RE: Wollen Short Plat (SP-08-05)

The Kittitas County Community Development Services Department has determined that the Wollen Short Plat is a complete application and hereby grants **conditional** preliminary approval subject to the following conditions:

WOLLEN SHORI PLAT

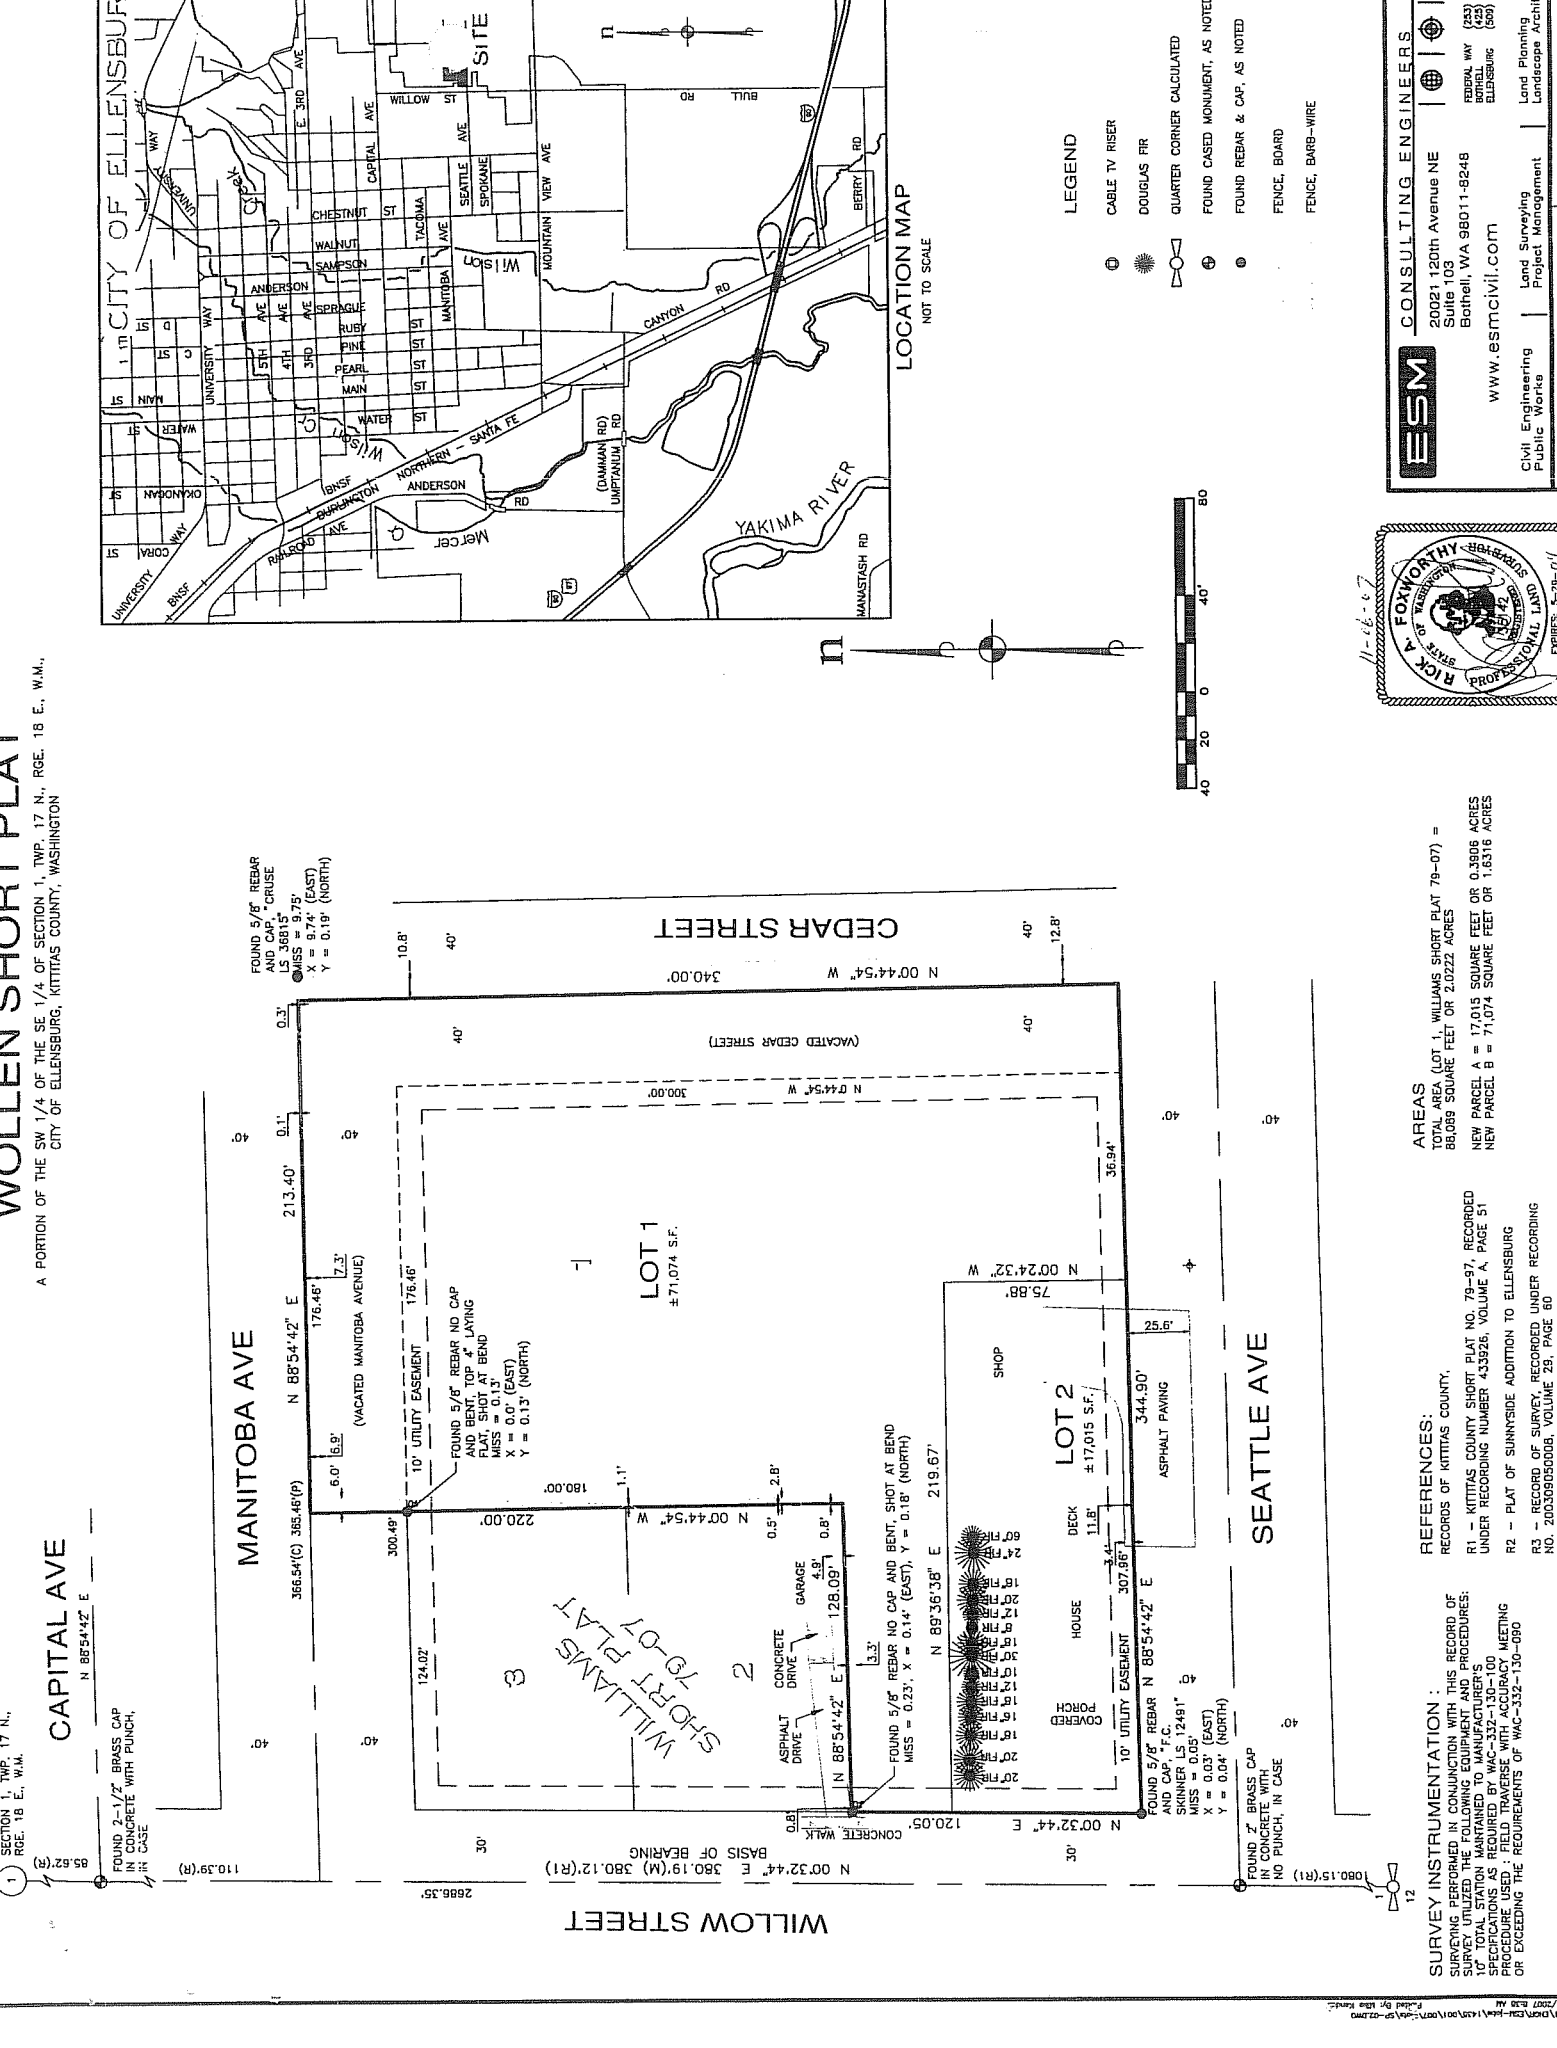
1. Both mylar sheets shall reflect the short plat number SP-08-05.
2. All future development must comply with International Fire Code (IFC) and appendices. .
3. All City of Ellensburg road and utility standards must be met. Attached you will find comments from Kittitas County Public Works. Please contact Christina Wollman at 962-7051 regarding all road standards and access questions.
4. Attached you will find comments from the City of Ellensburg. Please refer to these documents for required annexation, Outside Utility Agreement, road and utility standards that must be met and information on issues needing completion before final approval of this short plat.
